Our Ref: BE/28/22/NMA

**Section 96A of the Town & Country Planning Act 1990 (as amended)
Town and Country Planning (Development Management Procedure) (England) Order 2015
(as amended) - Article 10**

Non material amendment following BE/135/18/PL for alterations to approved external appearance of Units 6/7 and minor roof amendments.

Units 6/7 Land at Saltbox West of Shripney Road Bognor Regis PO22 9NW

Drg No KP-281-Units 6/7-NMA-01

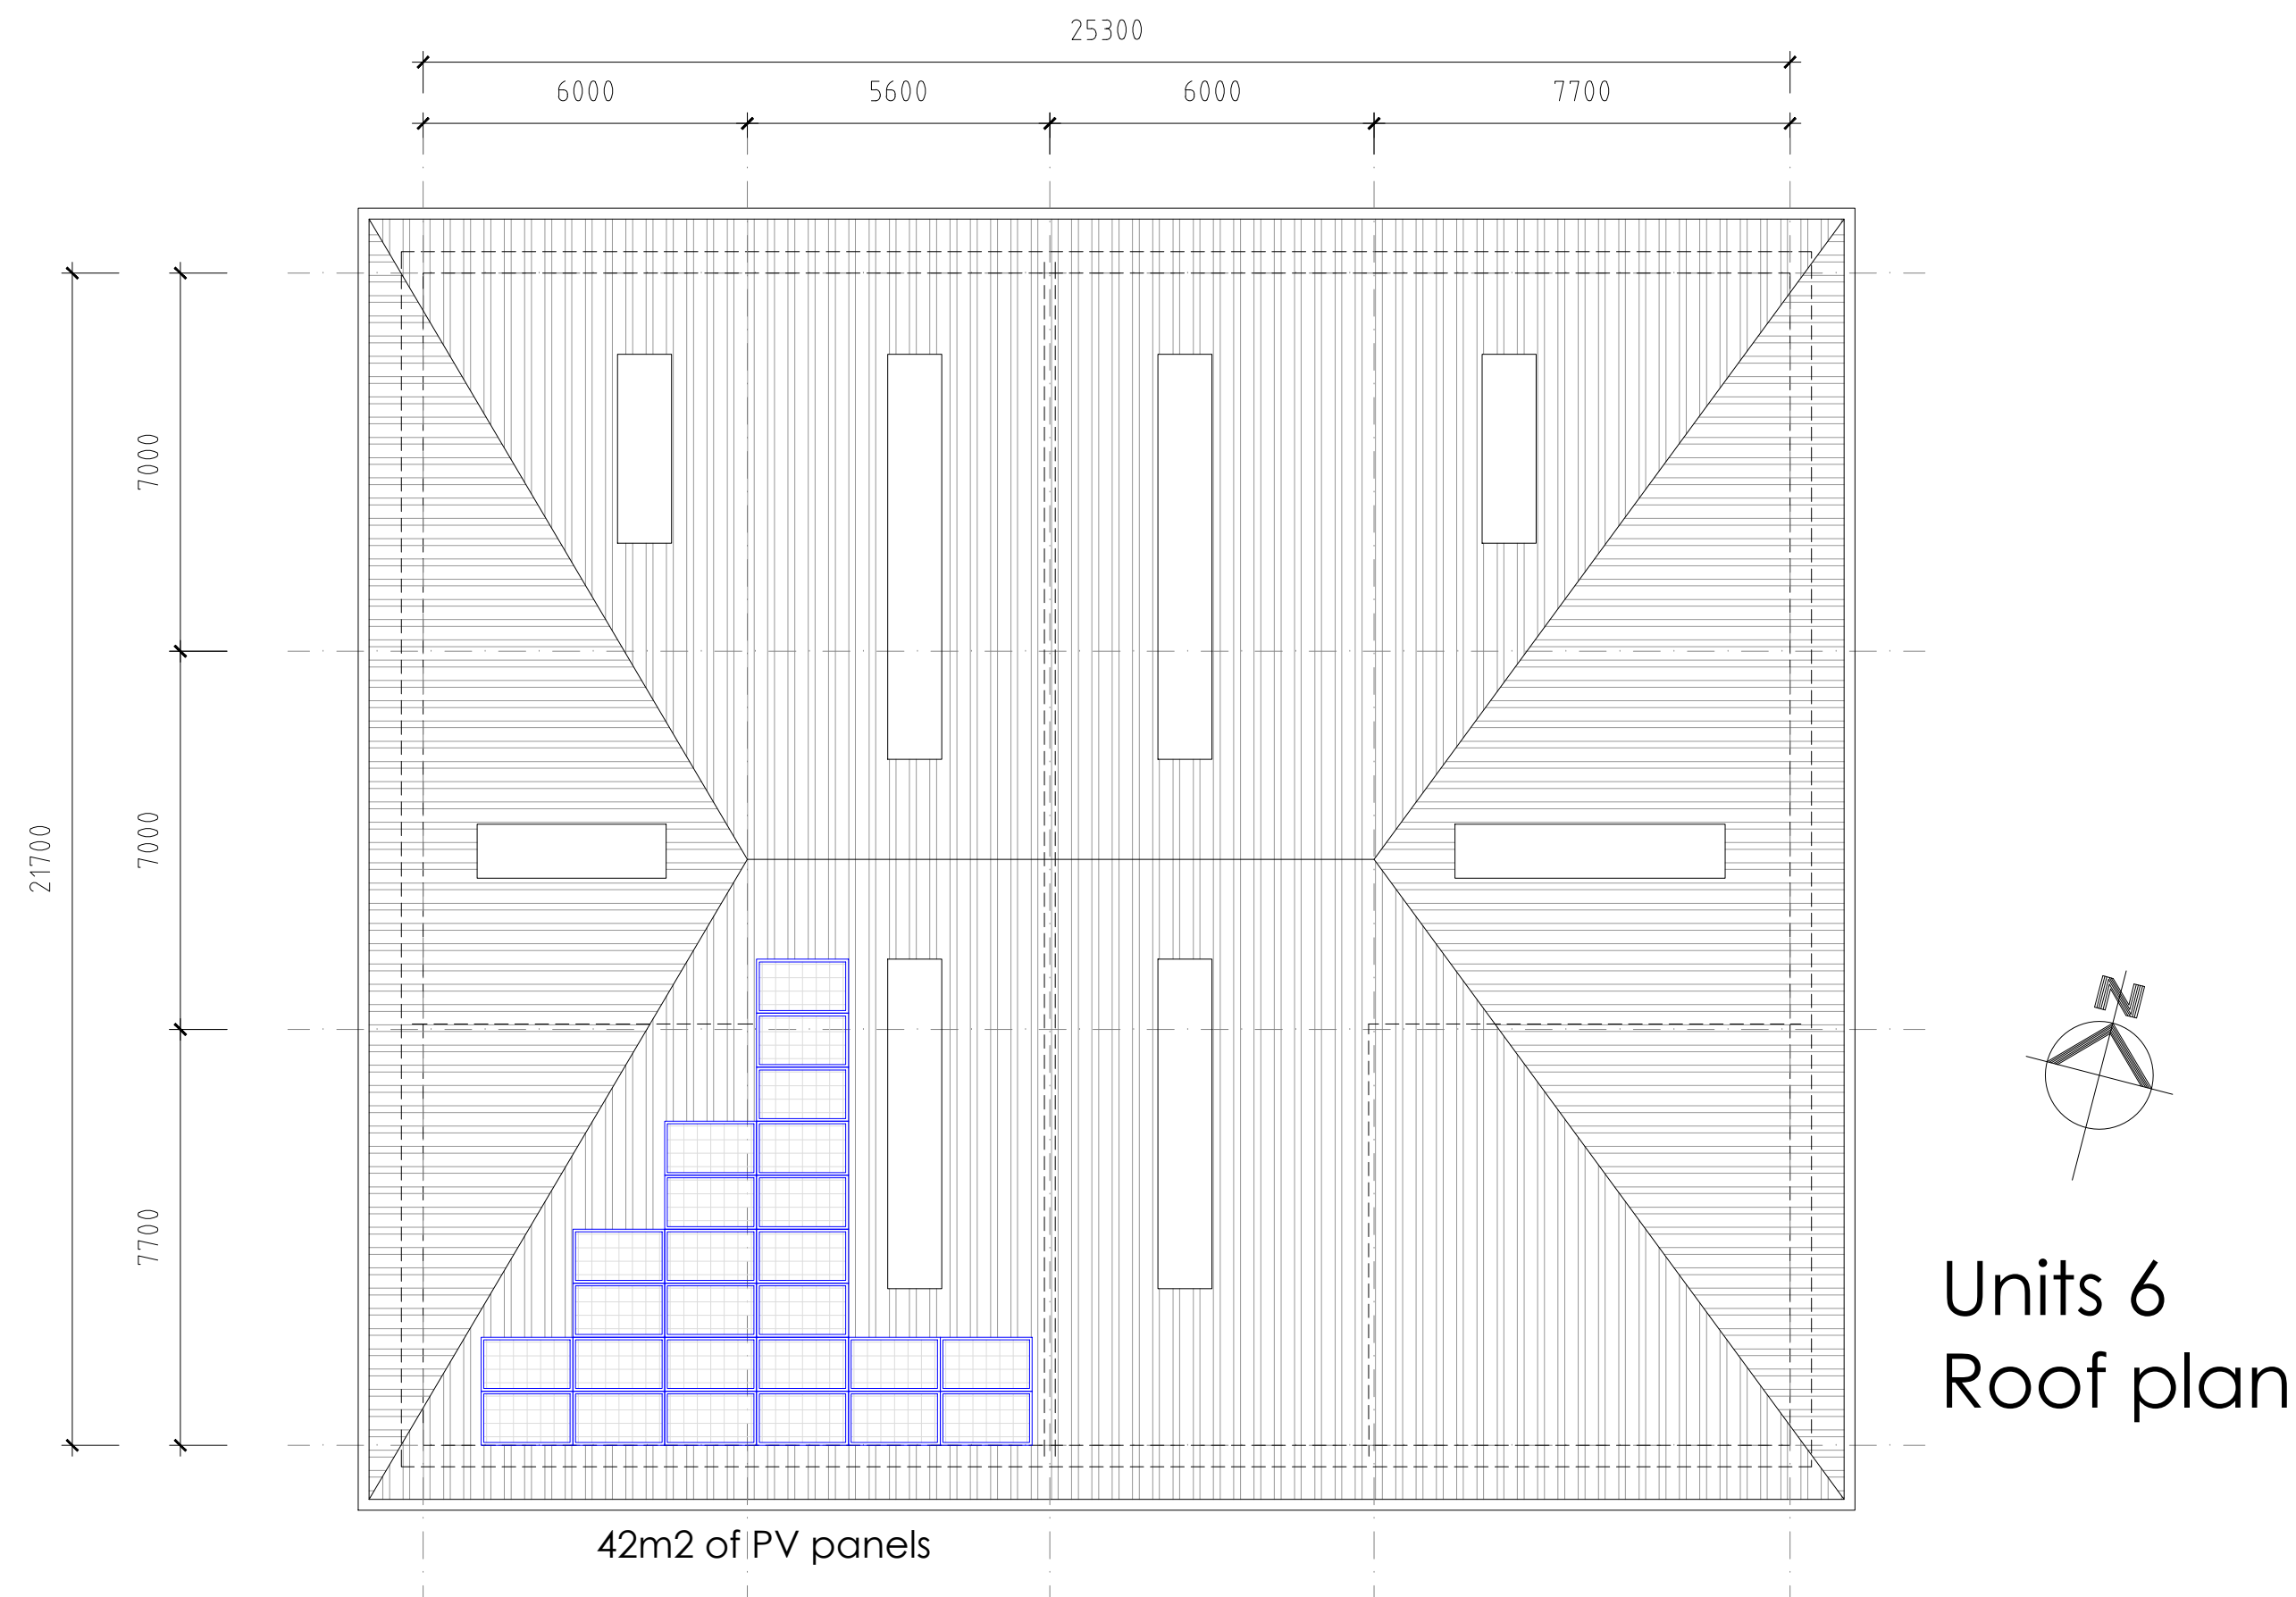
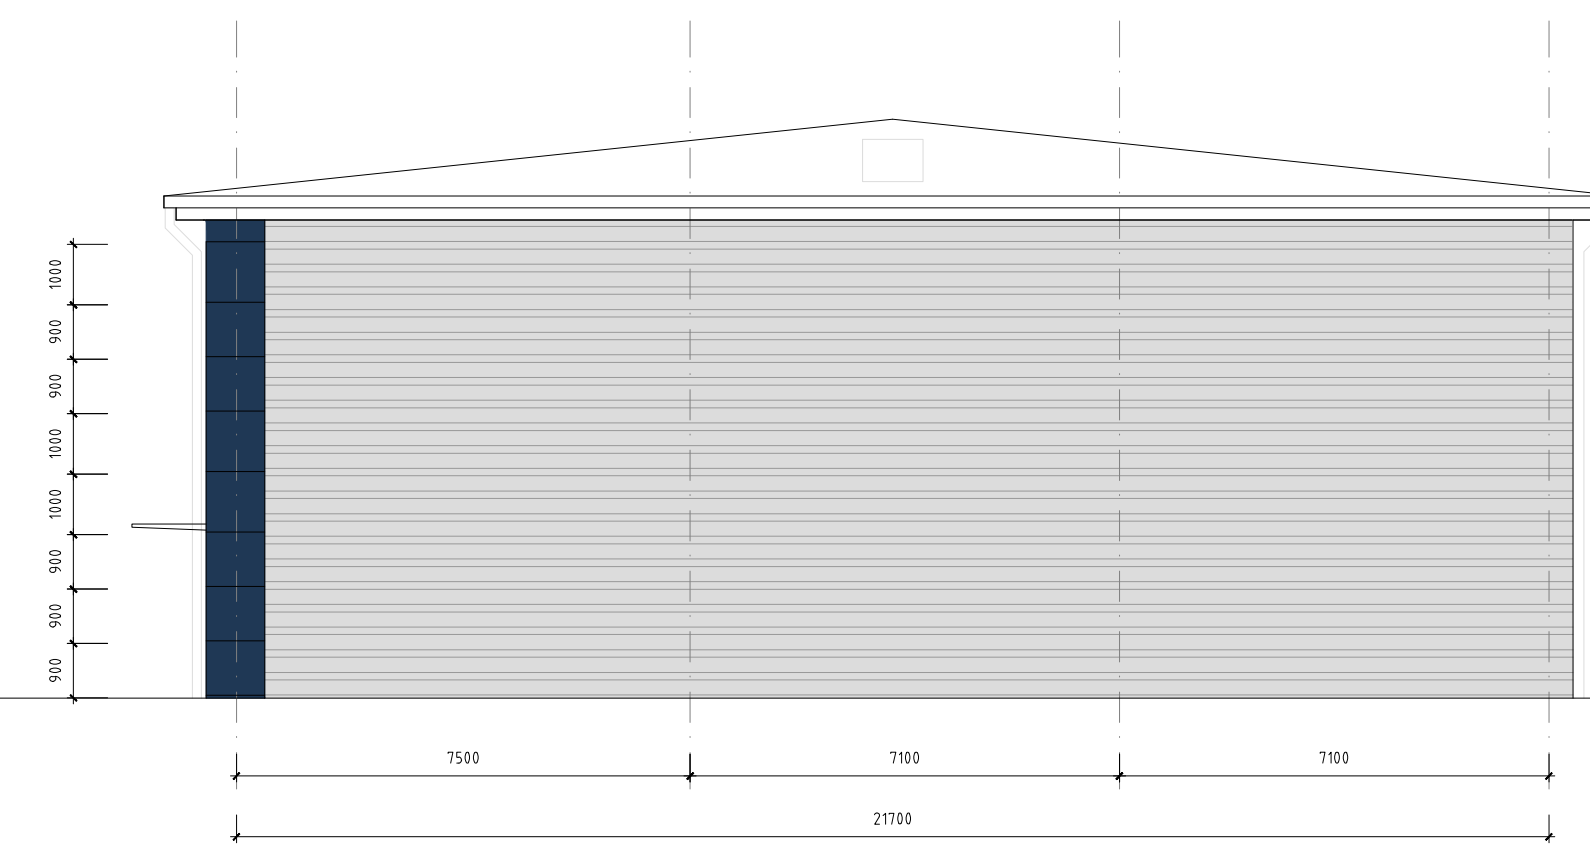
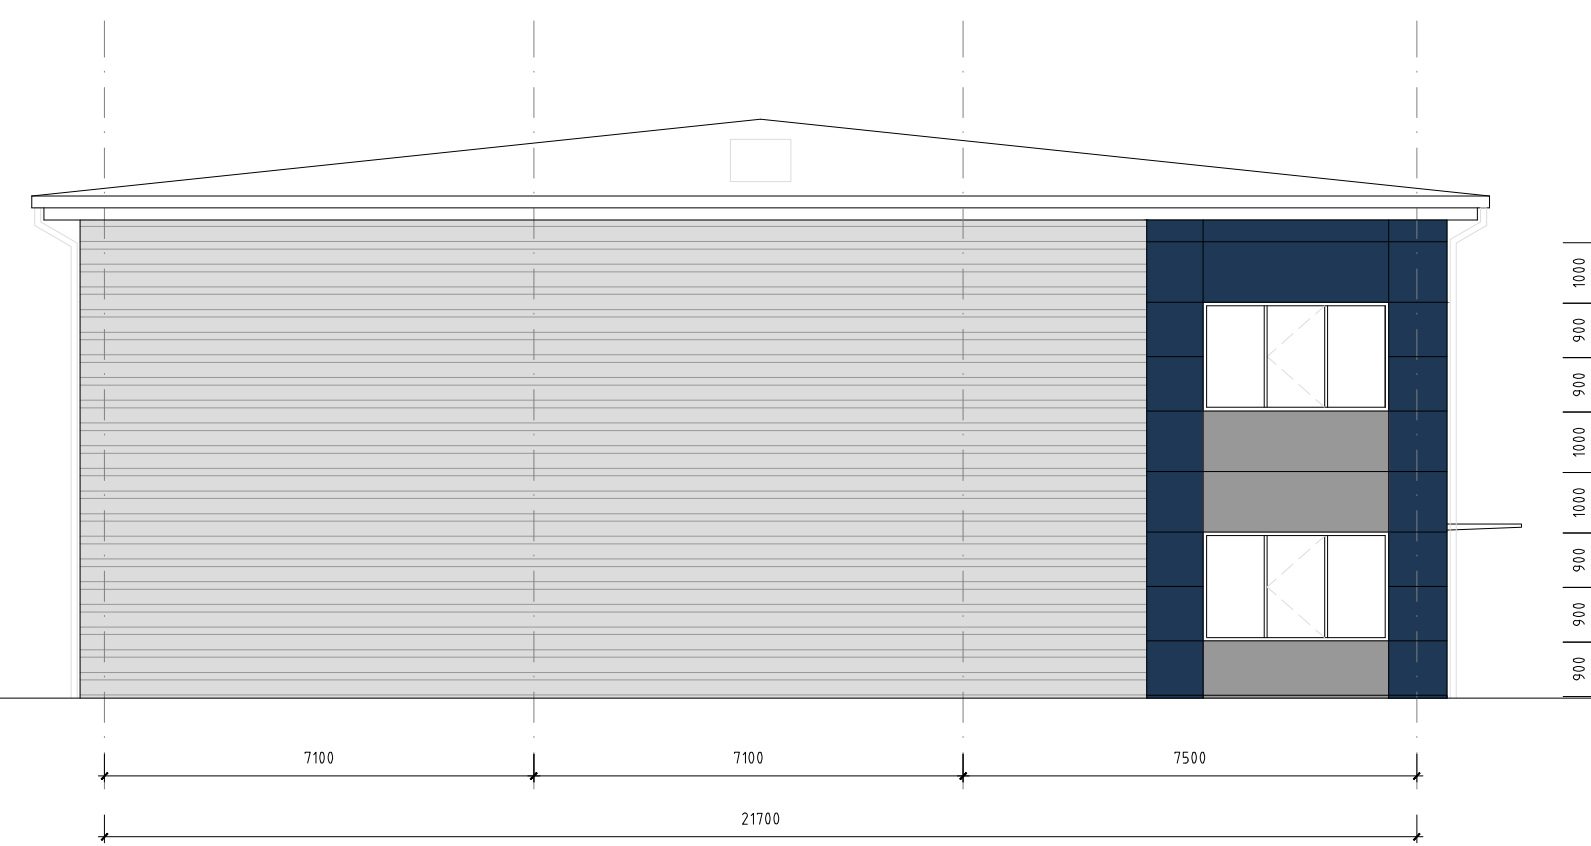
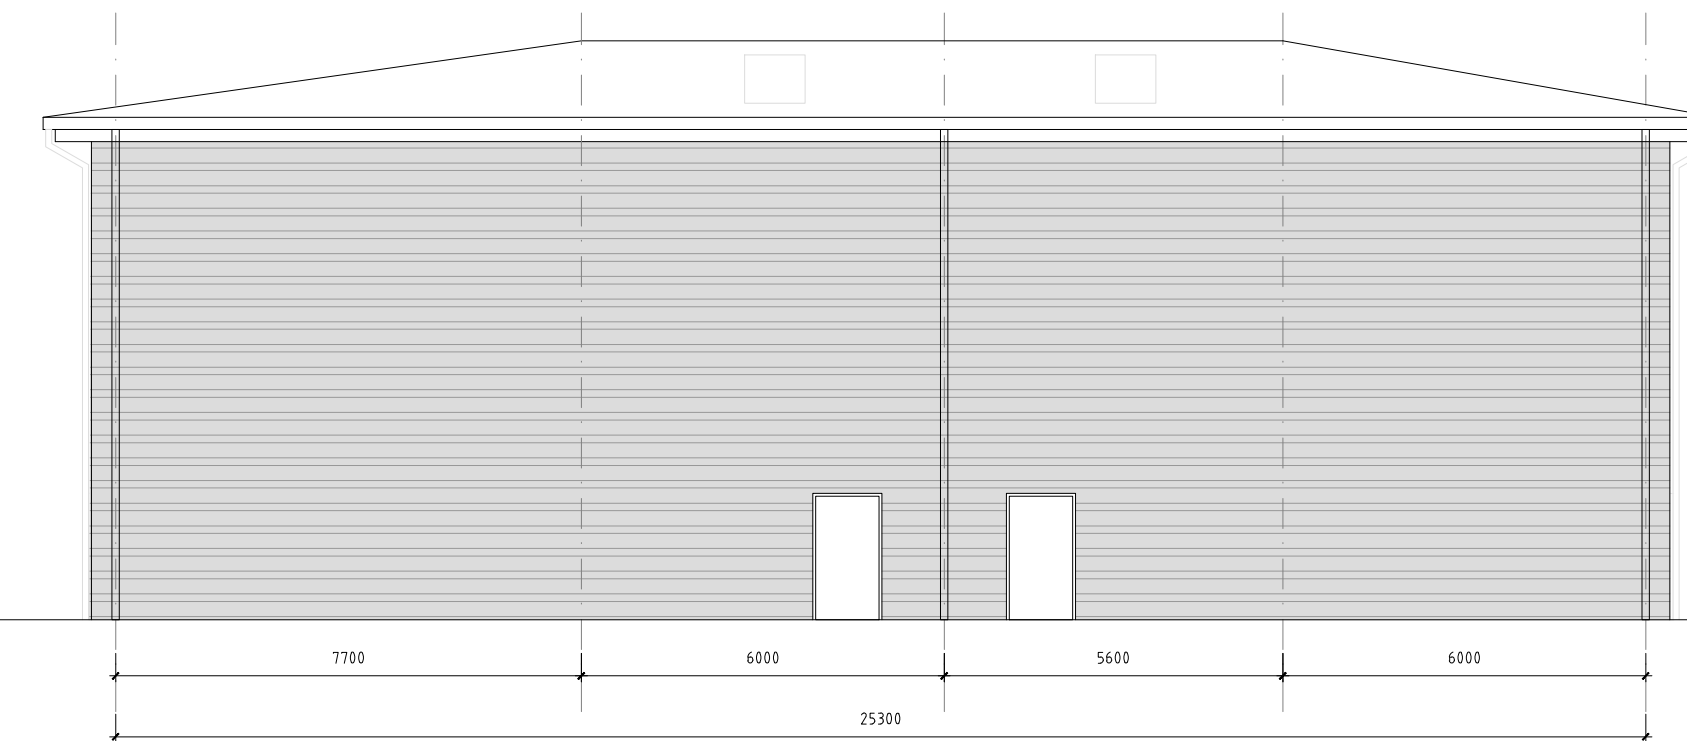
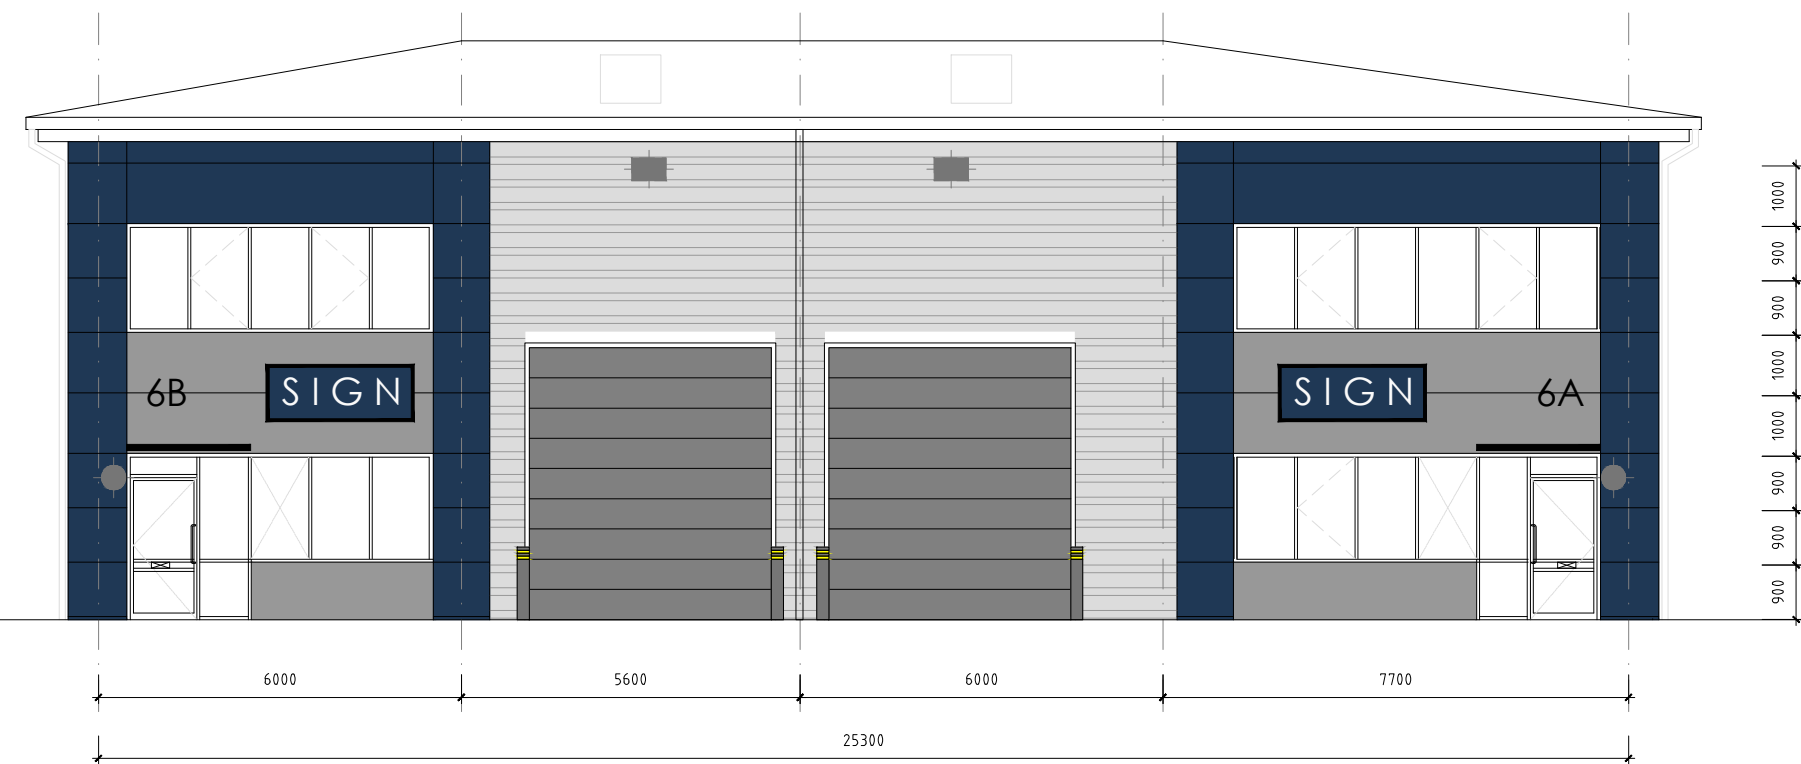
This Non-material amendment application seeks to change the roof to incorporate hip features at the west and east ends of the Unit 6 and 7. In addition to this, there are also proposed changes to the external materials. The units will continue to accommodate the intended 42sqm of Solar PV on the roof as approved under NMA application (BE/125/21/NMA dated 10th August 2021). There are no changes to the site layout scale or dimensions of the approved buildings.

The reason that this proposal has been accepted as a Non-Material Amendment is because it is amending the roof form, and materials of Unit 6-7. The proposal can therefore be considered under Section 96A of the Town and Country Planning Act 1990. As proposed change to a hipped roof and choice of materials would not change the description or conflict with any conditions imposed on the original planning application. The external materials now included:

- Profiled built-up roof cladding in HPS200 Goosewing Grey BS A10A05
- Circular RWPs in Grey Aluminium RAL 9006 or Sargasso Blue RAL 5003 to match adjoining

cladding.

- Gutter fascia in Grey Aluminium RAL 9007
- Horizontally laid profiled built-up wall cladding (half-round or trapezoidal) and related flashings in Metallic Silver colour RAL 9006
- Horizontally laid Microrib composite wall cladding in Sargasso Blue RAL 5003
- Horizontally laid Microrib composite wall cladding in Grey Aluminium RAL 9007
- Coloured insulate loading doors in Grey Aluminium RAL 9007
- Powder coated windows and curtain walling in RAL 9007
- Fire escape doors in RAL 9006 to match cladding
- Glazed spandrel panels
- Turn opening windows
- Unit name panatrim boards

Ian King Associates KP-281-Units 6/7-NMA-01 and KP281-Units 6/7-NMA-02 now form part of the approved planning drawings for BE/135/18/PL at Saltbox in place of:

1744-TU-P04B (Proposed Roof Plan) and 1744-TU-P05C (Proposed Elevations)
